Application Ref.: F/4/20/OUT

Proposal: Outline planning application (with all matters reserved except for access) for the development of up to 1,500 dwellings (Use Class C3), 60-bed care home (Use Class C2), up to 9,000 sqm of employment floorspace (Use Classes B1), local centre of up to 2,350 sqm including up to 900 sqm retail/ commercial (Use Classes A1-A5) and 1,450 sqm community/ leisure floorspace (Use Classes D1-D2), land for a two-form entry primary school (Use Class D1), public open space, allotments, new sports pitches and associated facilities, drainage, parking and associated access, infrastructure, landscape, ancillary and site preparation works, including demolition of existing buildings and part removal of existing runway hardstanding.

Location: Land at Ford Airfield Ford

Further to our previous objections to these proposals, we have now reviewed the Waste Infrastructure Statement (WIS) dated February 2021.

Figure 4: Typical illustrative plan showing noise mitigation principles, subject to detailed noise assessment and layout planning at reserved matters stage. Not for approval of detailed block layout or type/mix of housing.

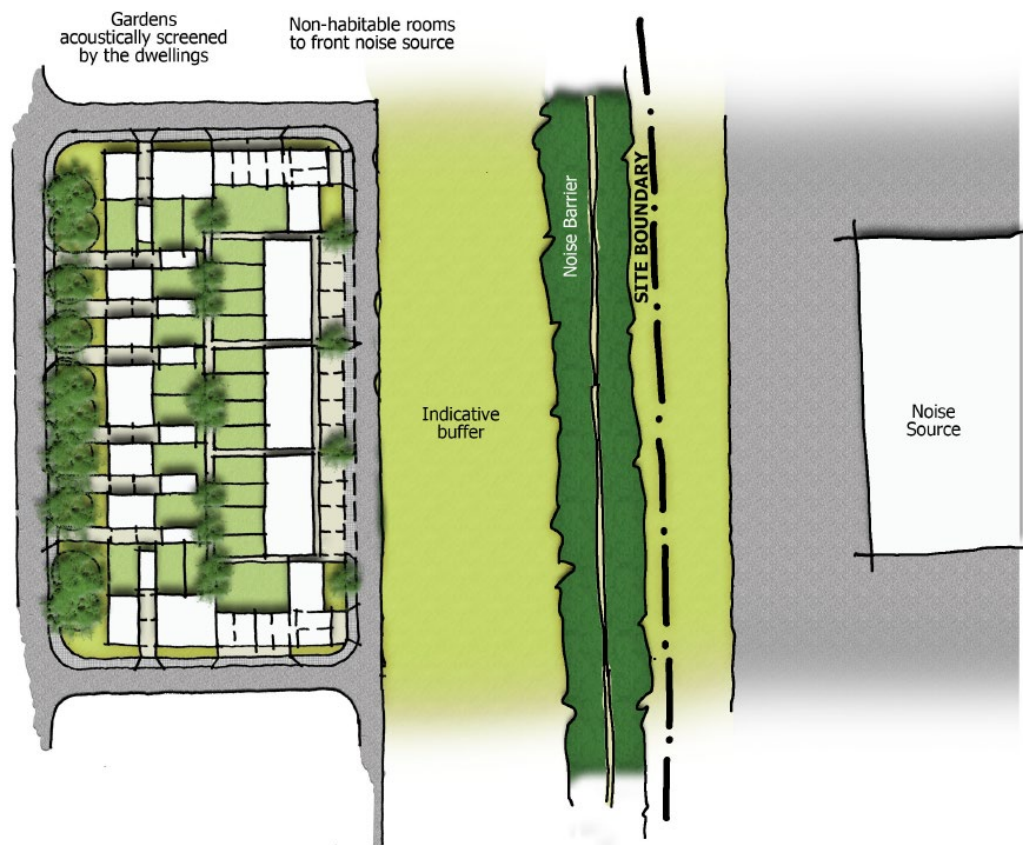
It is worth noting that the indicative illustrations shown on page 30 of the WIS do not show any acoustic mitigation at the boundary with Ford CTP. Elsewhere within The Landings development acoustic barriers and/or acoustic bunds have been proposed

alongside boundaries with other sources of noise however it is unclear why this has been ruled out along the boundary with Ford Circular Technology Park.
